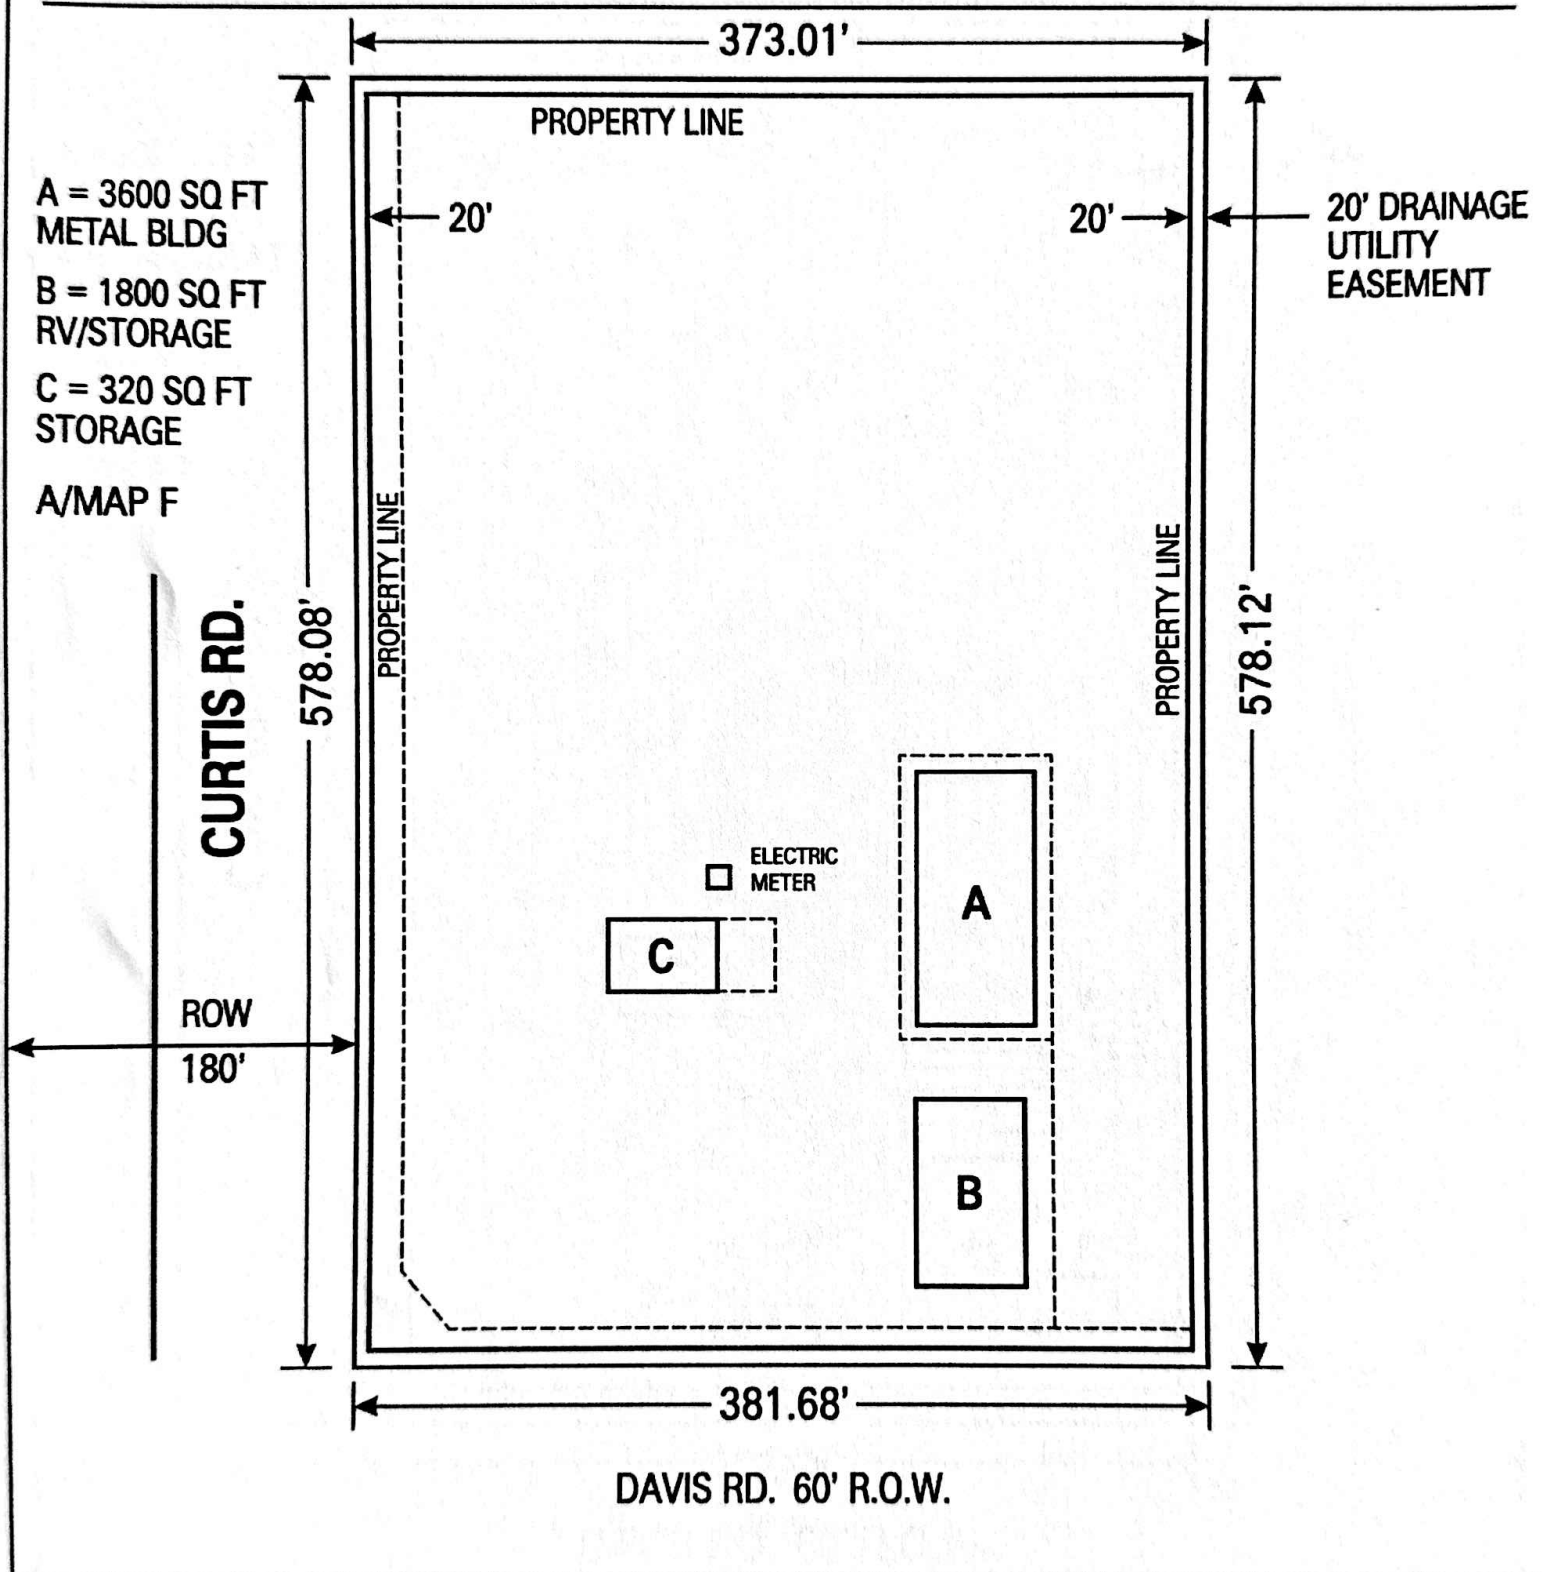
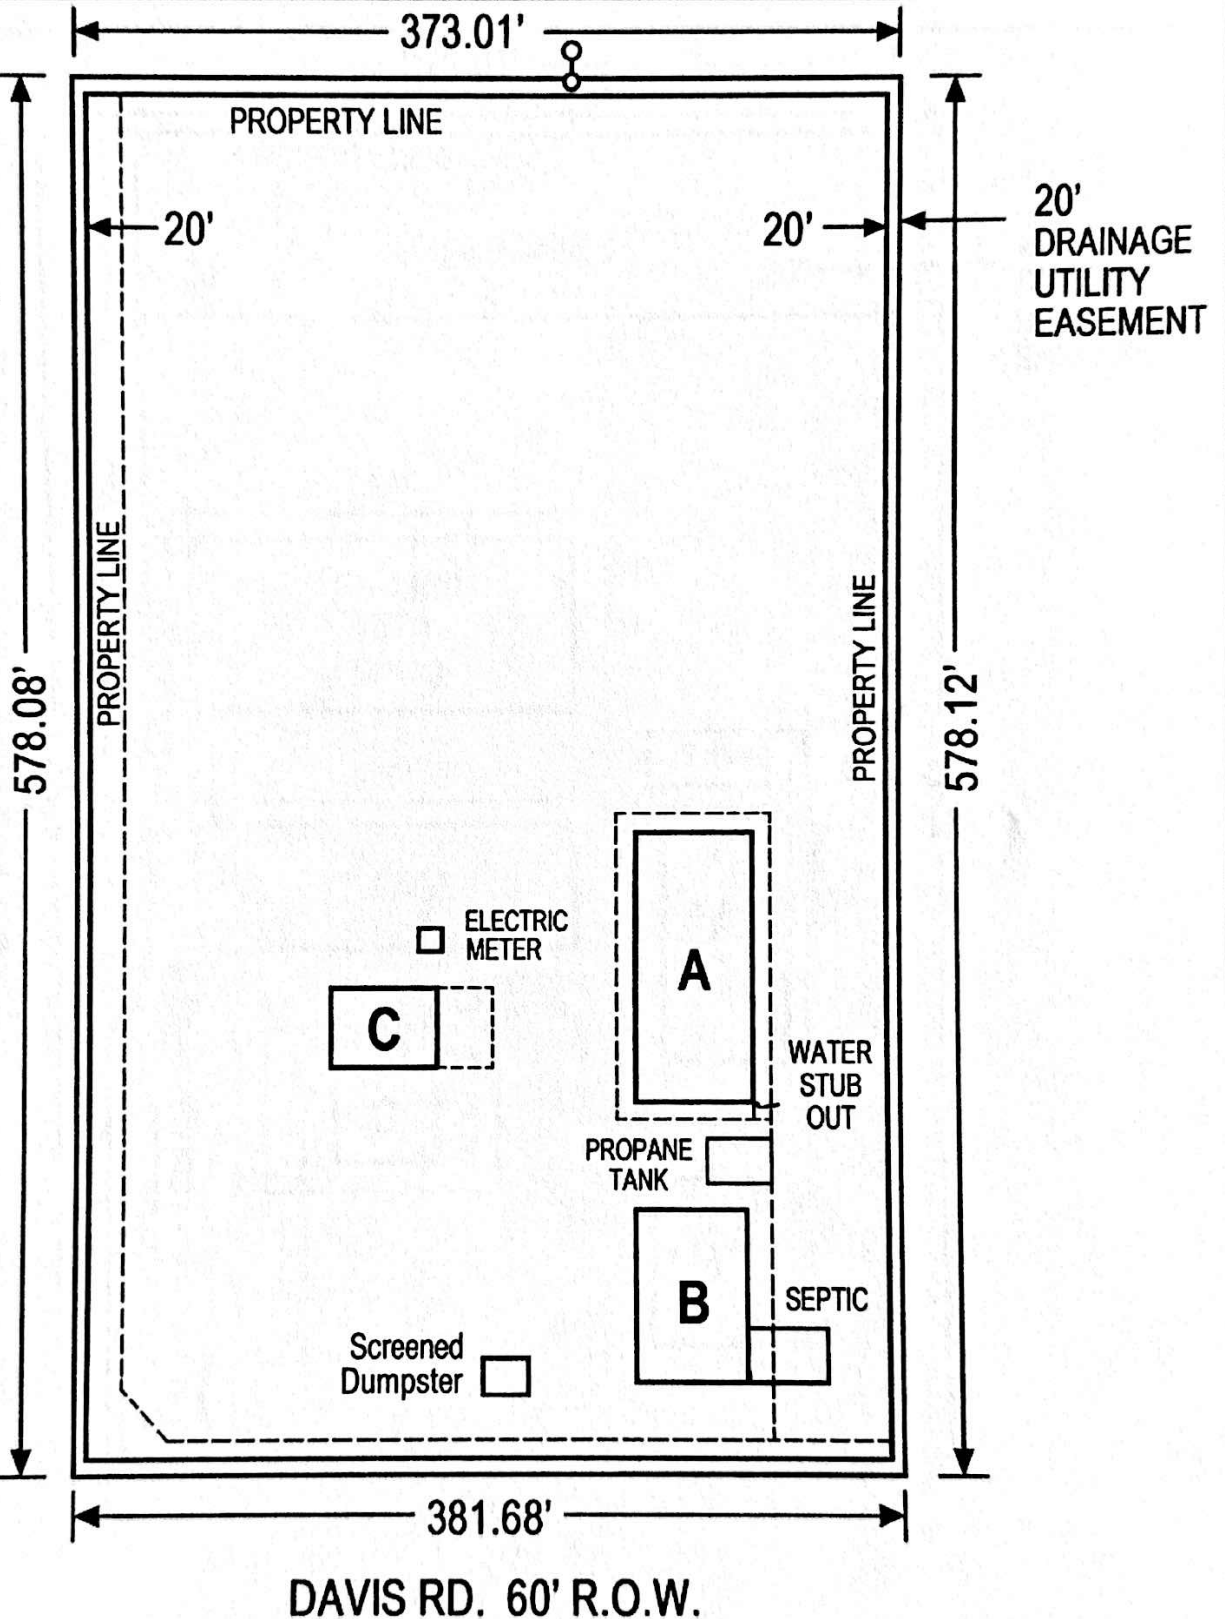
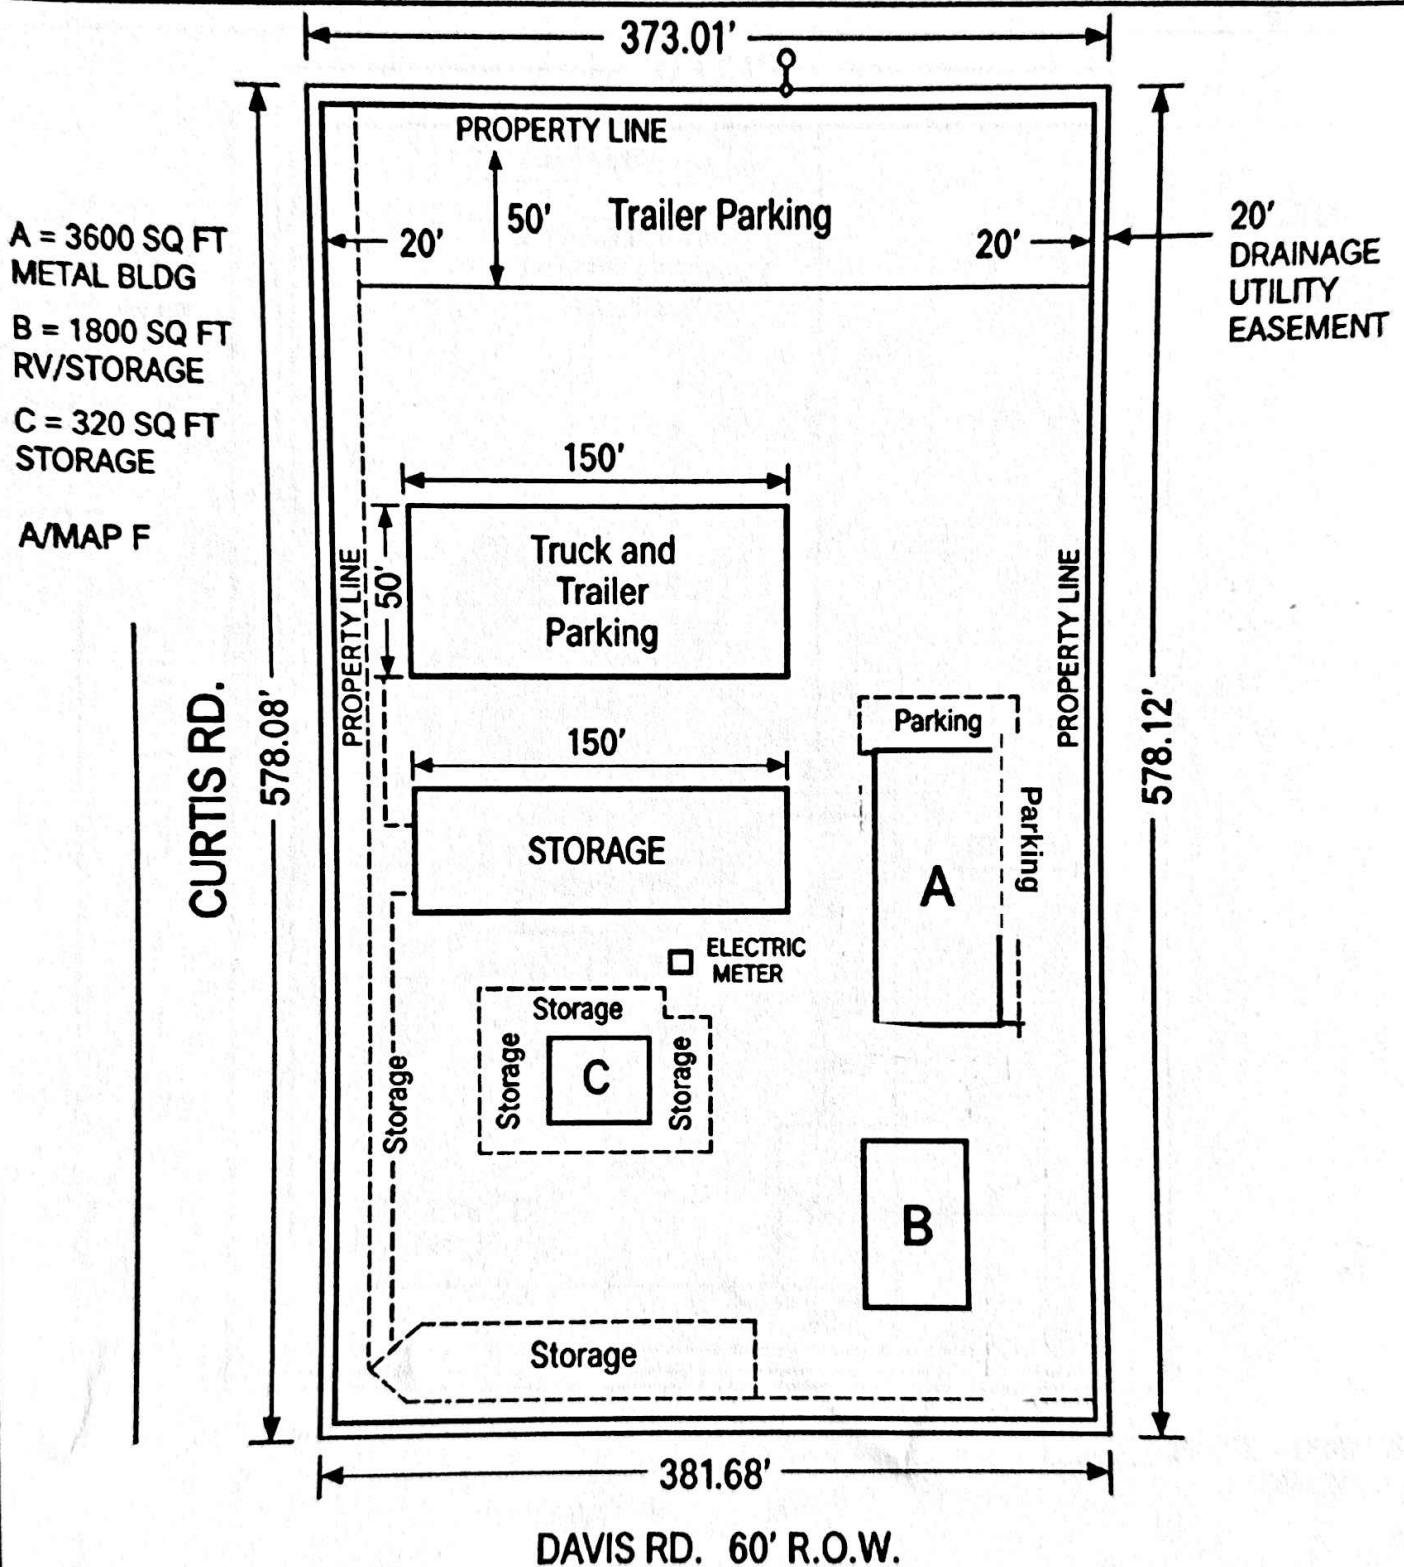
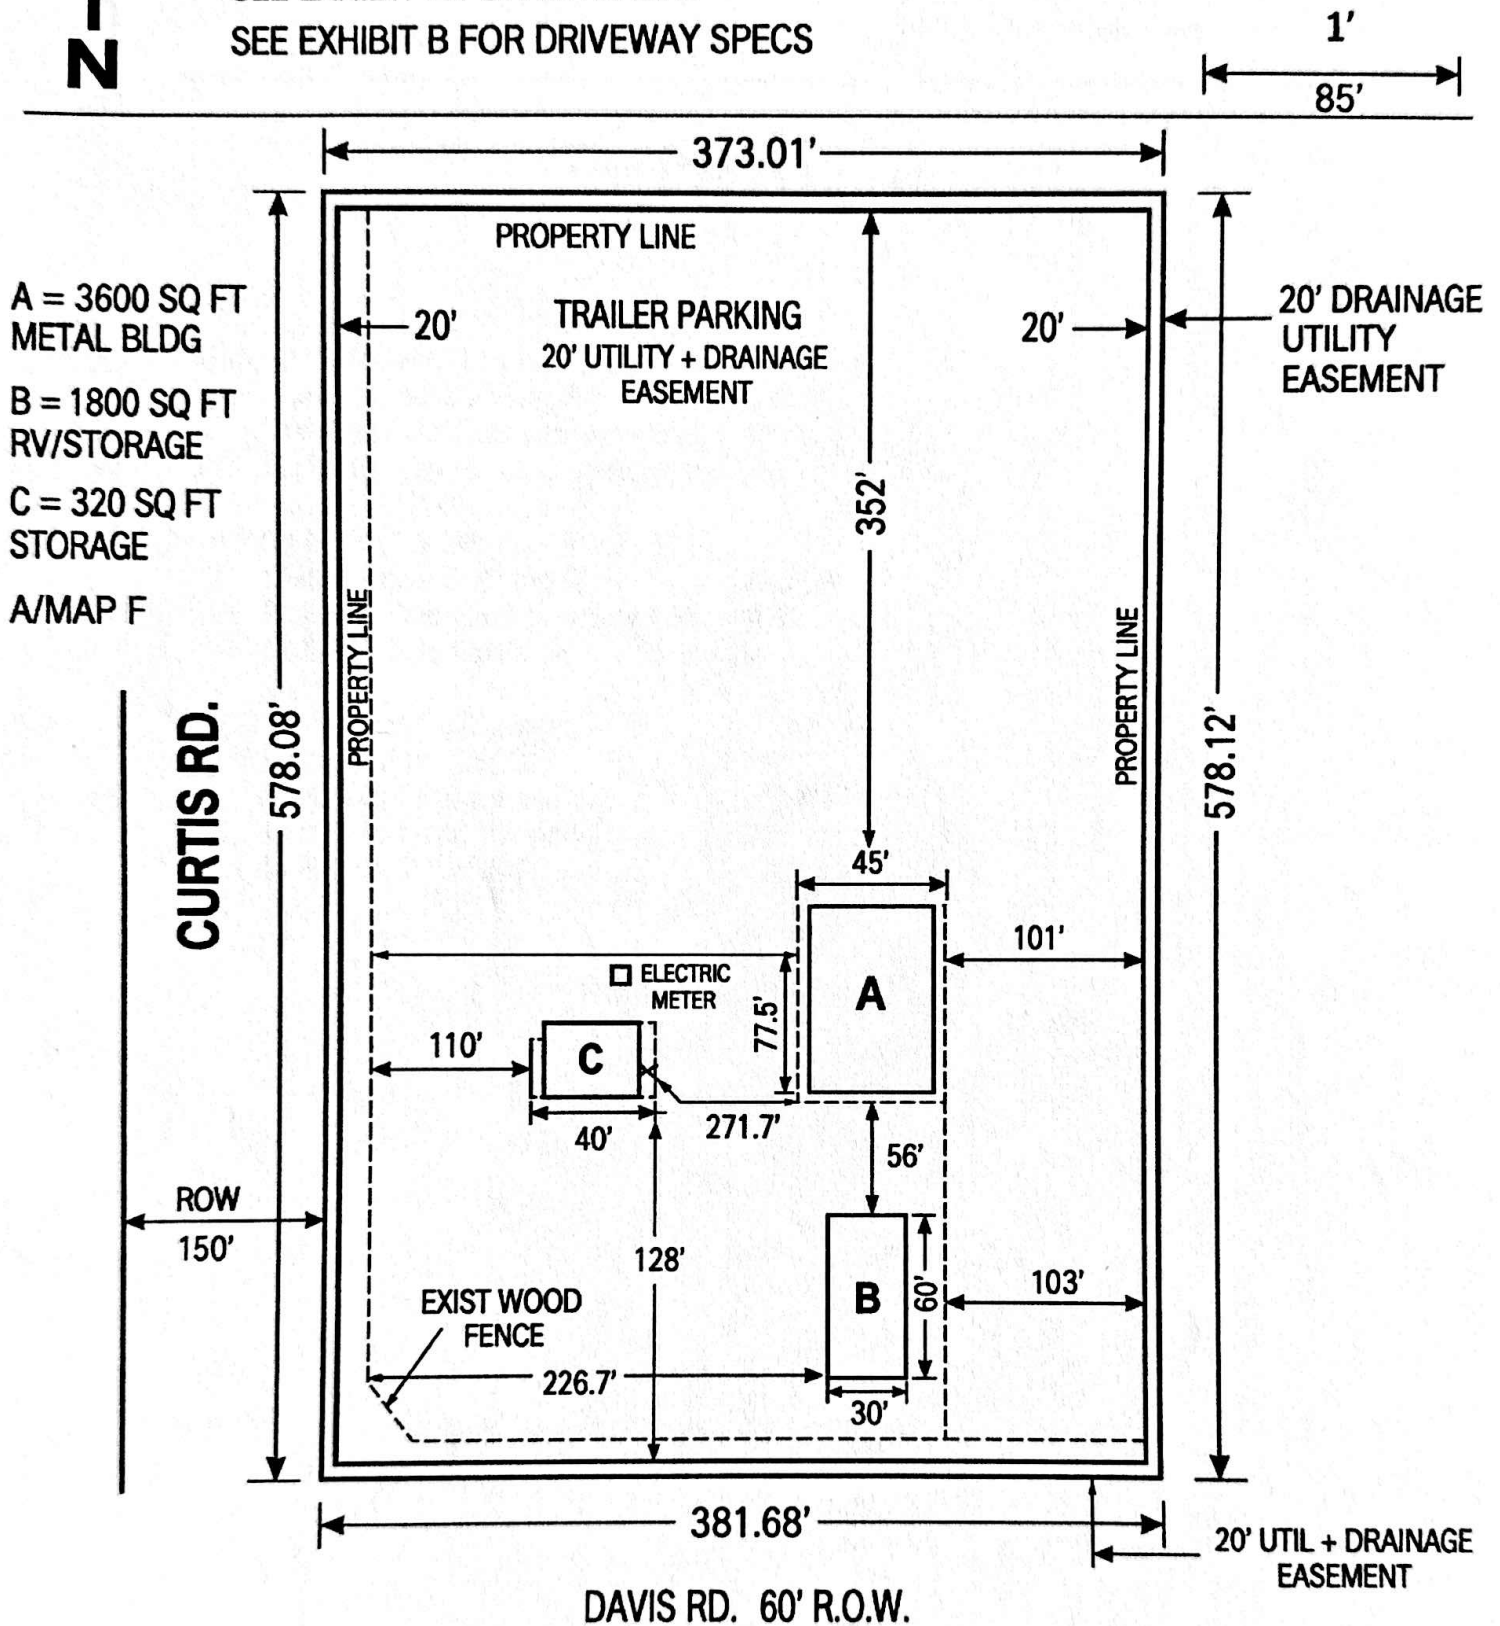
See comment on first page. This area needs to be screened, and any vehicles or objects over 6 feet need to be 50 feet from the property line. It is recommended to move the entire storage area to be 50 feet off all property lines to prevent confusion.

depict existing walls
and fences.

all storages areas to
be labeled

Remove 2nd access

Road classification of Davis Road and access spacing does not support 2nd access.

Add note below to Site Development Plan and completed EPC Road Impact Acknowledgement Form

The owner (s) agree on behalf of him/herself and any developer of builder successors and assignees that subdivider and/or said successors and assigns shall be required to pay traffic impact fees in accordance with the El Paso County Road Impact Fee Program (Resolution No. 25-337), or any amendments thereto, at or prior to the time of building permit submittals. The fee obligation, if not paid at final plat recording, shall be documents on all sales documents and in plat notes to ensure that a title search would find the fee obligation before sale of the property.
